Development Application Permit Review

COMMUNITY SERVICES DEPARTMENT
 Park Operations - Community Outreach - Environmental Services
 Veterans Services - Recreation / Cultural Services

Name:	Lorson Ranch East Filing No. 3 Final Plat	Application Type:	Final Plat
PCD Reference #:	SF-193	Total Acreage:	19.50
		Total # of Dwelling Units:	81
Applicant / Owner:	Owner's Representative:	Dwelling Units Per 2.5 Acres:	10.39
Lorson, LLC	Lorson, LLC	Regional Park Area:	4
Jeff Mark	Jeff Mark	Urban Park Area:	4
212 N. Wahsatch Avenue, Suite 301	212 N. Wahsatch Avenue, Suite 301	Existing Zoning Code:	PUD
Colorado Springs, CO 80903	Colorado Springs, CO 80903	Proposed Zoning Code:	PUD

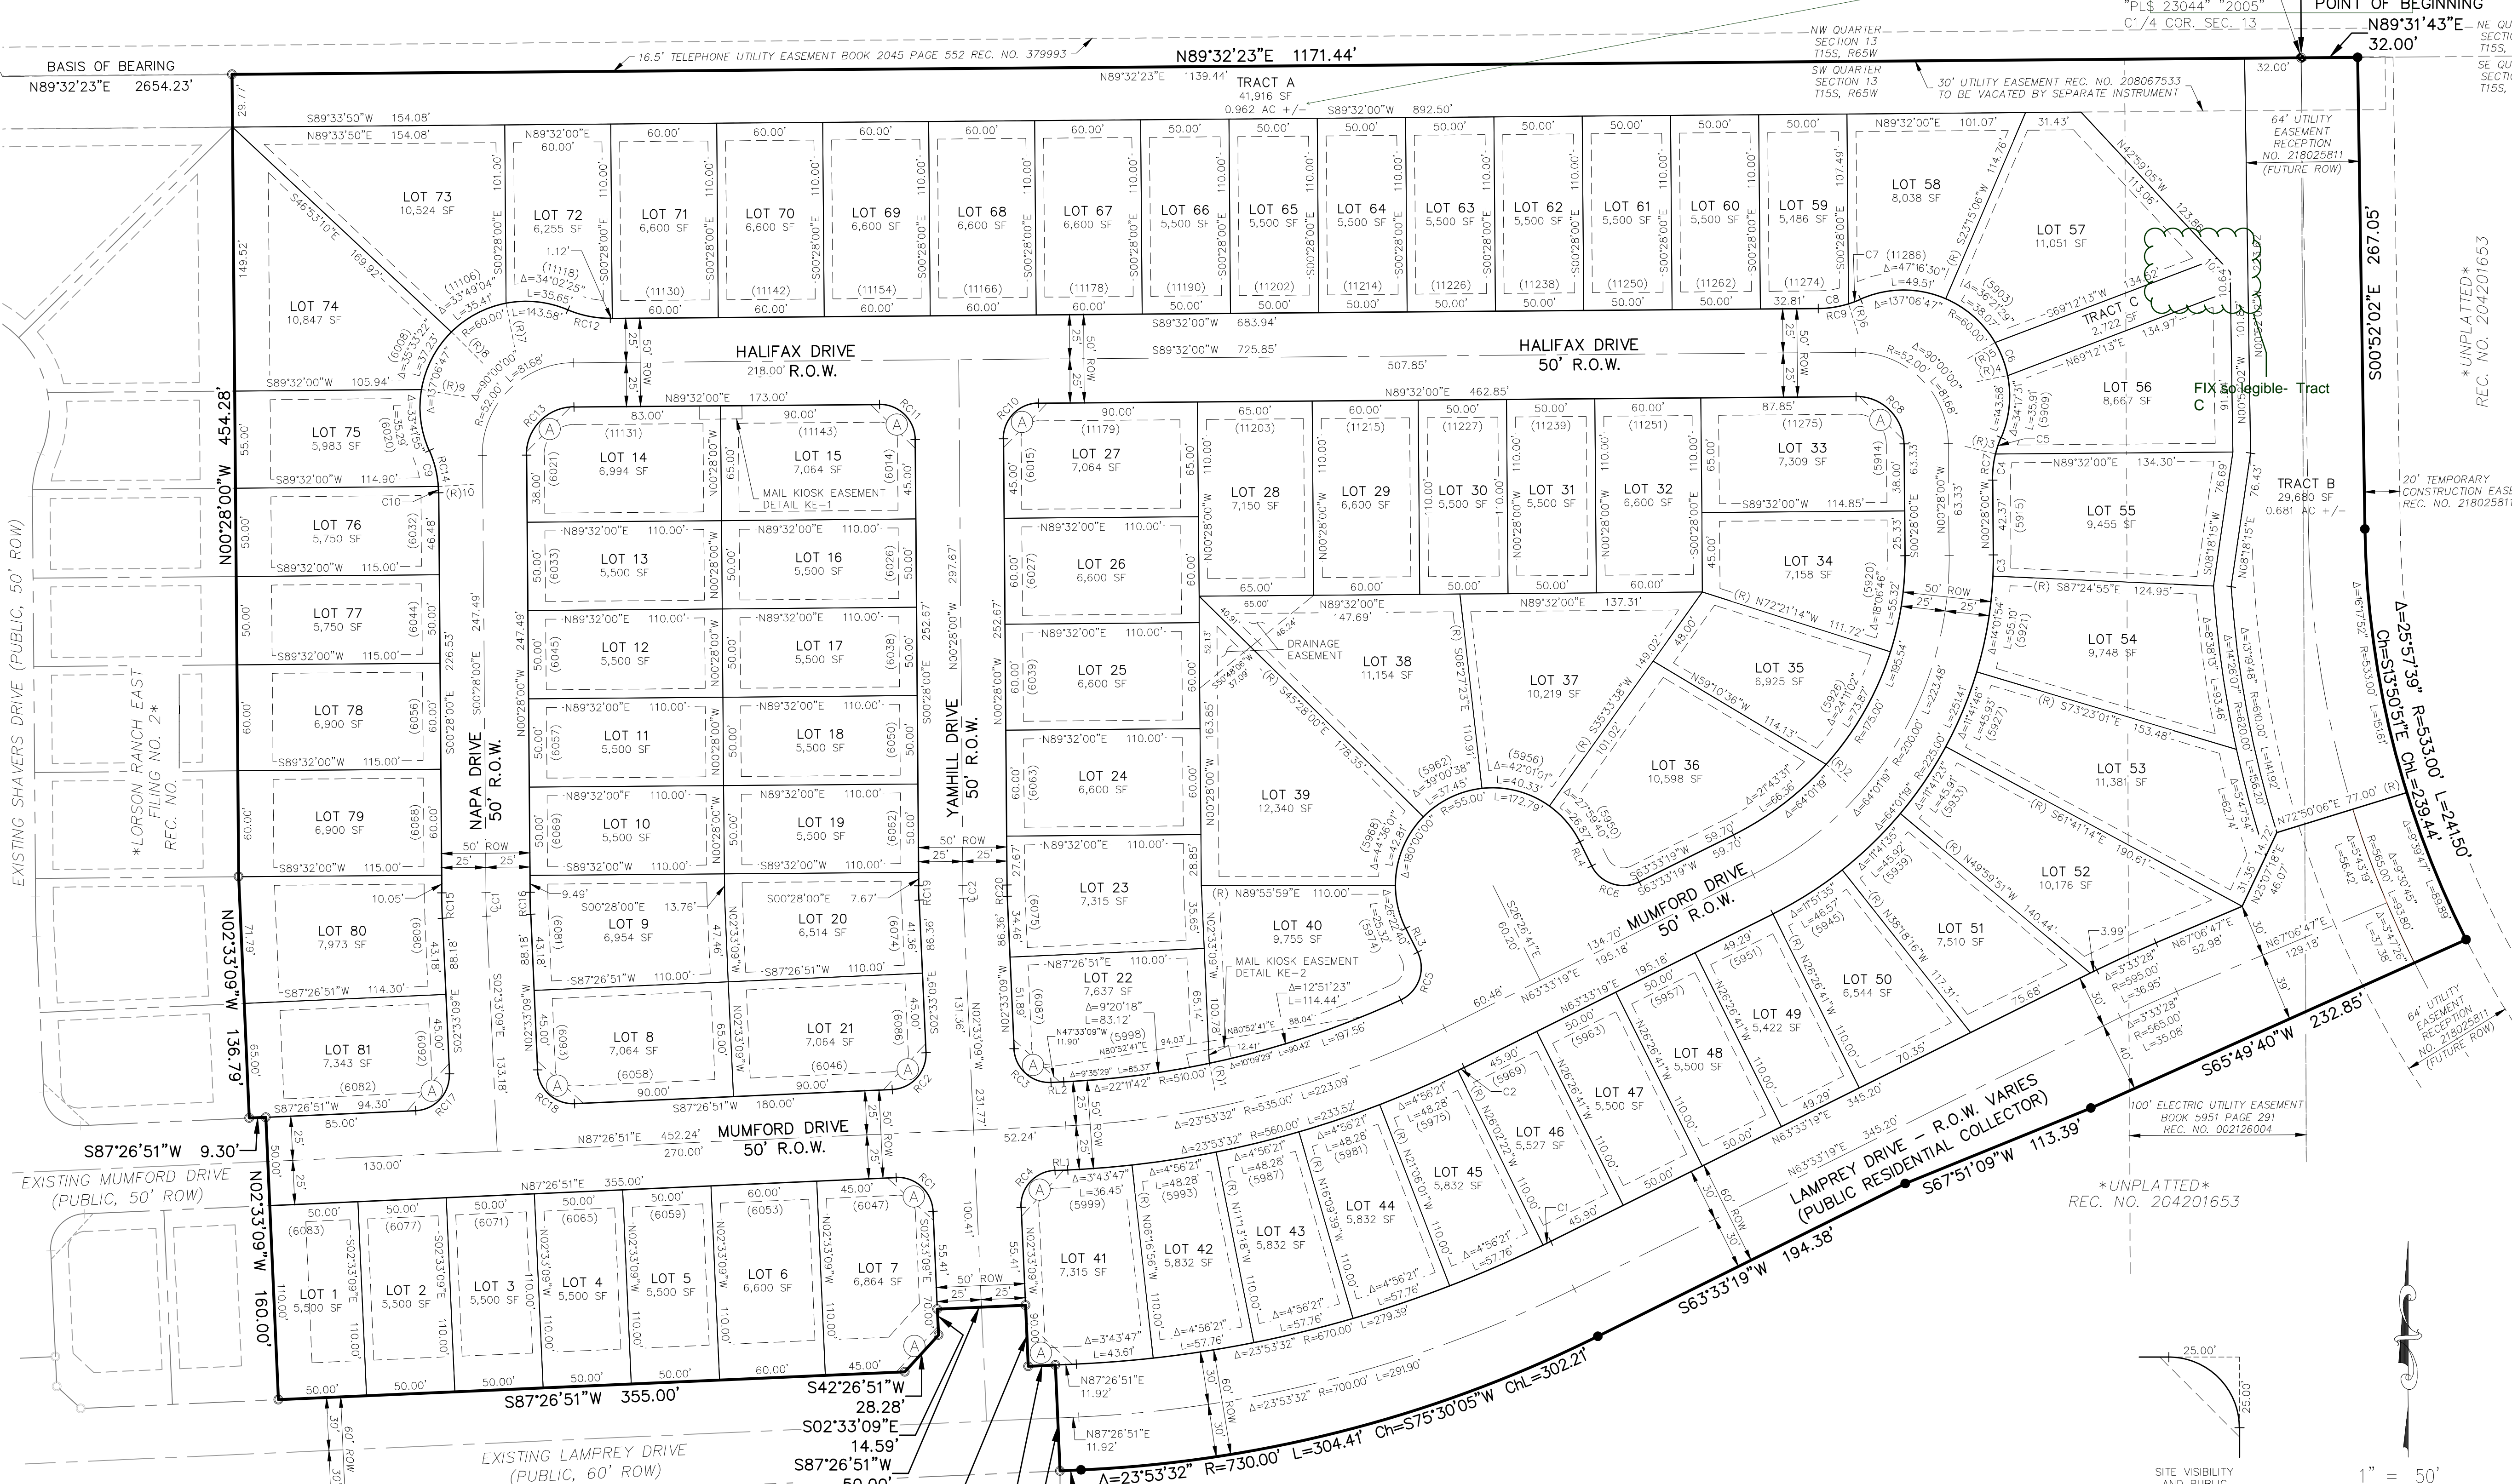
Staff Recommendation: Recommend to the Planning Commission and Board of County Commissioners that approval of Lorson Ranch East Filing No. 3 Final Plat include the following conditions: (1) Show non-County trails within Tract A on the final plat drawings consistent with the previously approved PUD Development and Preliminary plan (2) require fees in lieu of land for regional purposes in the amount of \$36,936 and urban fees in the amount of \$23,328. A park lands agreement may be an acceptable alternative to urban park fees provided the agreement is approved by the County and executed prior to recording the final plat.
